### TRANSIT STOP FOR METRO

**From:** Celina Daniell  
**To:** ["tridge@gpmetrobus.com"](mailto:tridge@gpmetrobus.com)  
**Cc:** [Bo Kennedy](#); [Stephen Bushey](#)  
**Subject:** FW: midtown, Portland ME - proposed bus stop/shelter for review  
**Date:** Tuesday, November 11, 2014 12:49:00 PM  
**Attachments:** [C-2.1.pdf](#)  
[C-2.2.pdf](#)  
[C-2.3.pdf](#)

**From:** Robert Woodman [<mailto:rwoodman@fstinc.com>]  
**Sent:** Wednesday, October 16, 2013 9:16 AM  
**To:** [tridge@gpmetrobus.com](mailto:tridge@gpmetrobus.com)  
**Cc:** [gjordan@metrobus.com](mailto:gjordan@metrobus.com)  
**Subject:** midtown, Portland ME - proposed bus stop/shelter for review

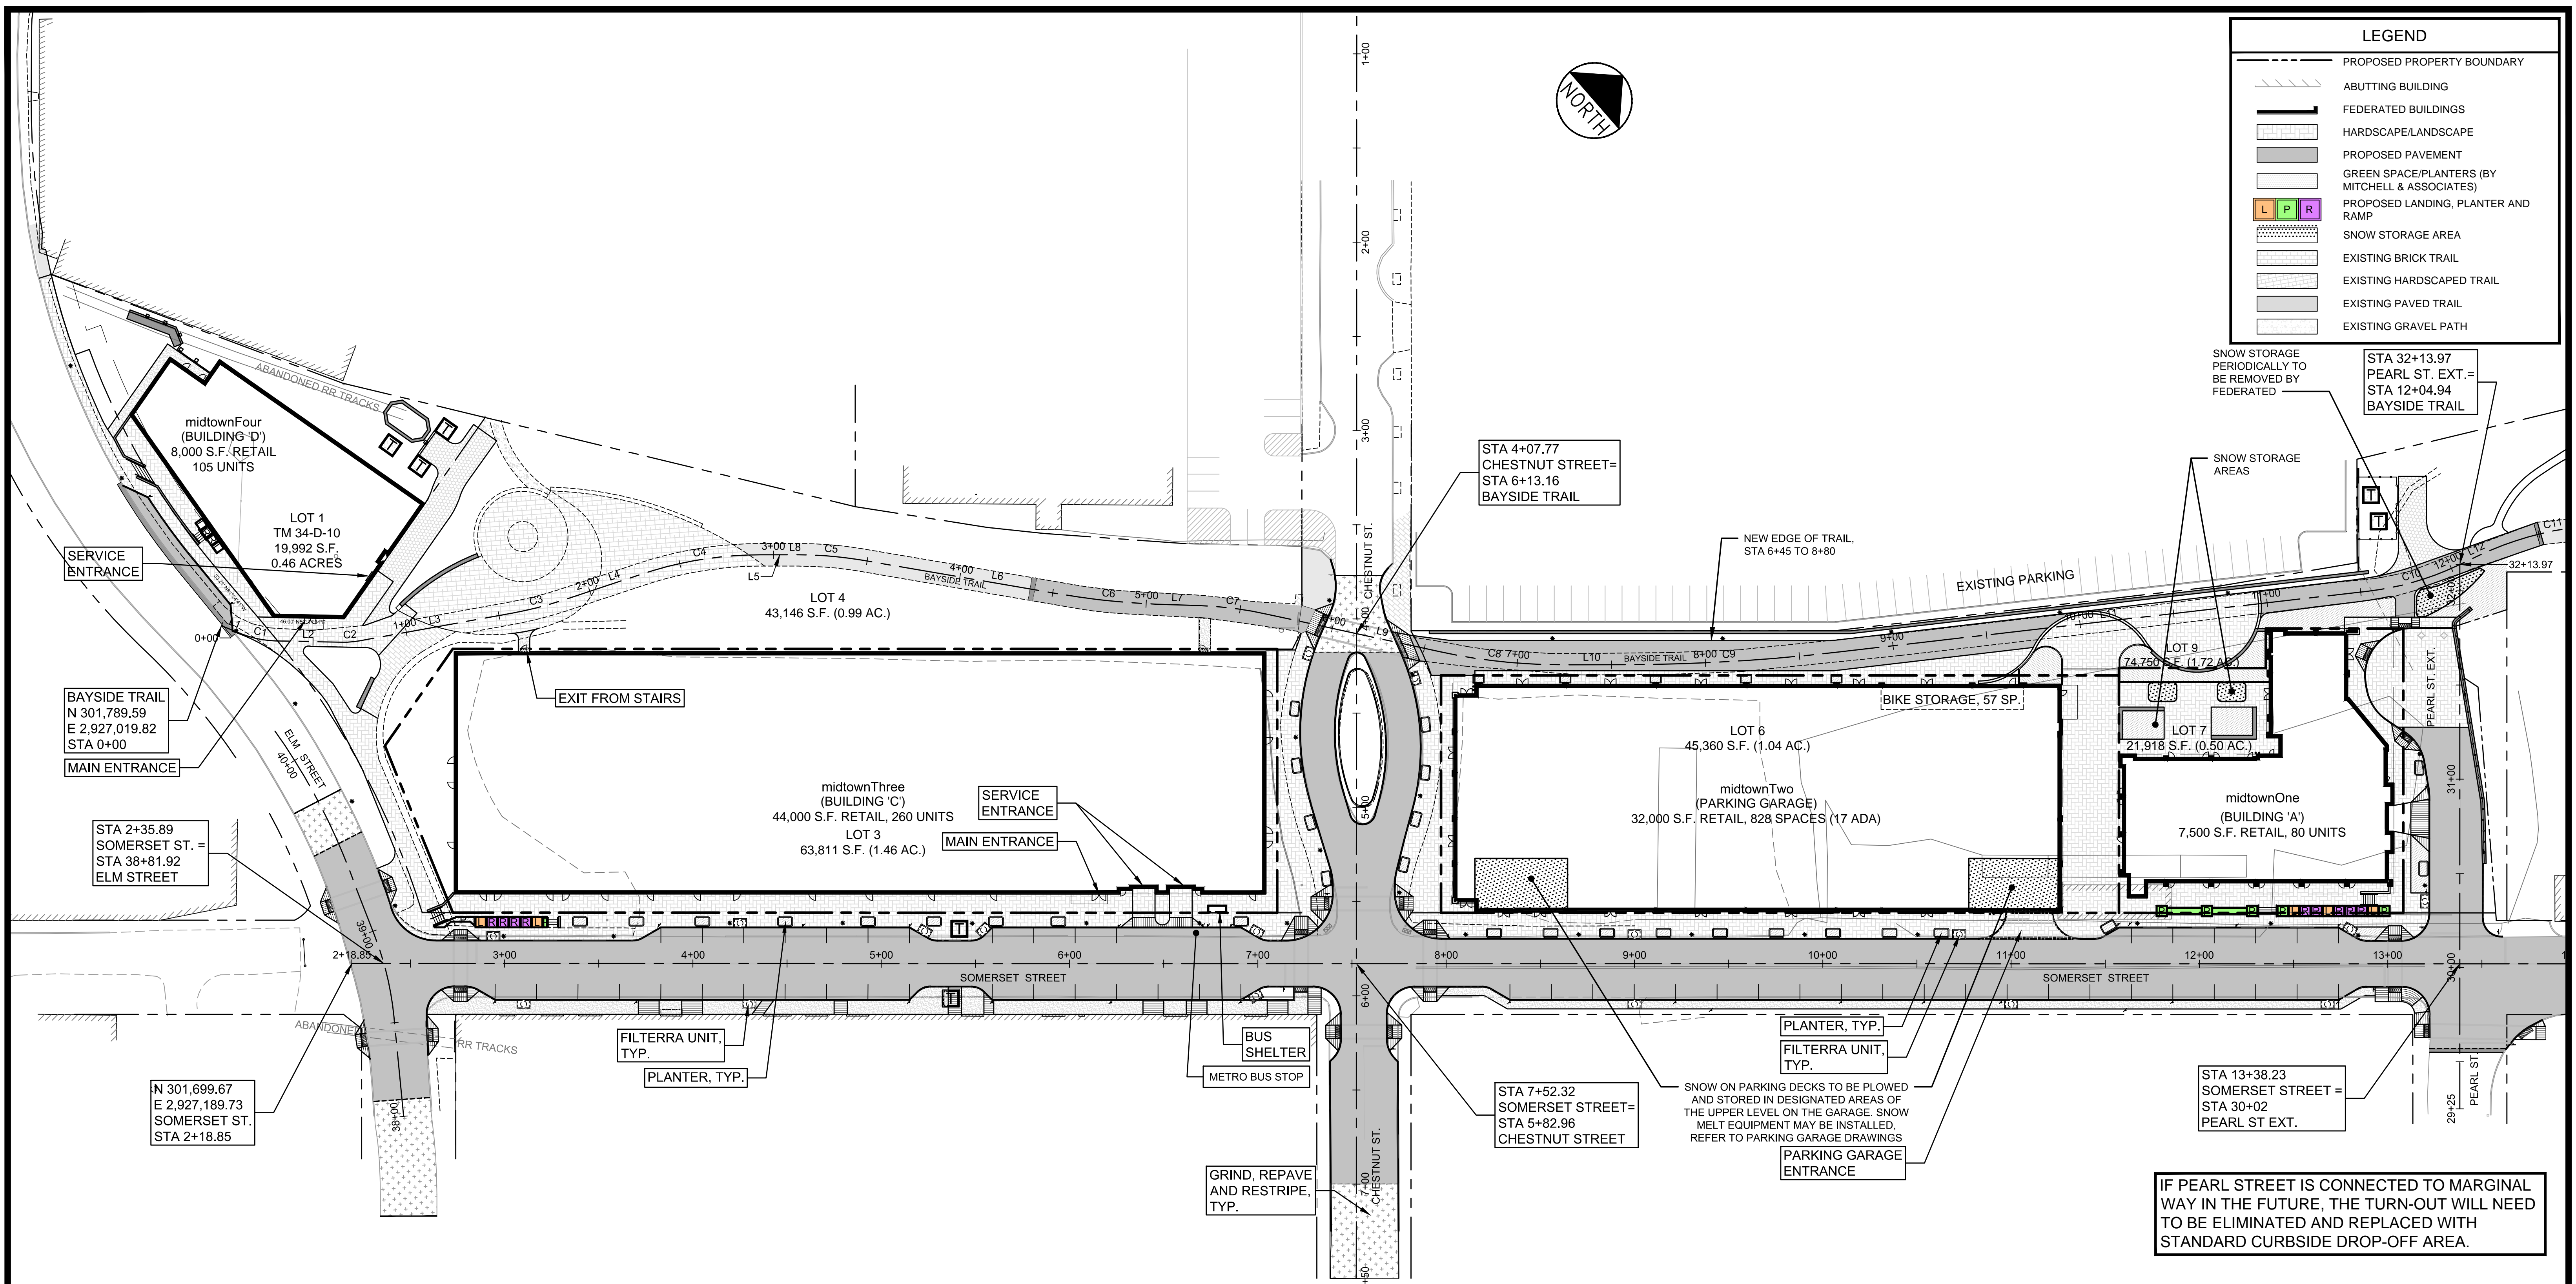
The plan identifies a bus stop on the northerly side of Somerset Street adjacent to ‘midtown 2’.

The designated bus stop bump out is approx. 70 feet long with 13’ long tapers on each end.

We are seeking your review of this location and feedback as to whether or not the proposed location and design will work for METRO.

- 70' with angled ends is enough space for our bus to get in off the road

- Metro will provide a sign for the stop when the pole is installed at the far end of the bay
- City “No Parking Bus Stop” signs will be installed at beginning, middle, and end of bay
- The shelter location will be somewhere from middle bay to far end
